**Application no: 23/03073/HYBRID**

**Location:** Phase 2 SW Bicester Kingsmere Parcel R East Of, Ludlow Road, Bicester

## **Transport Schedule**

Table 3.2: Proposed Pedestrian Connection

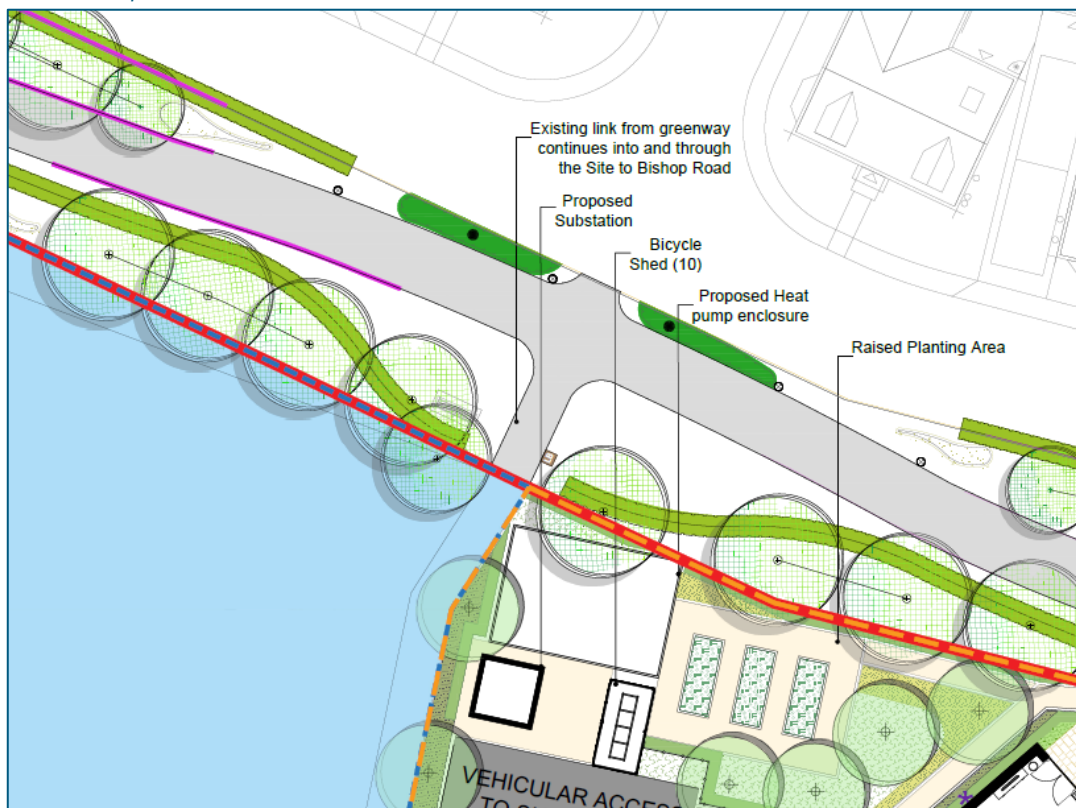
**A pedestrian / cycle link to the northwest of the site (near the turning head / substation), connecting to the residential access should be provided / suitably conditioned.**
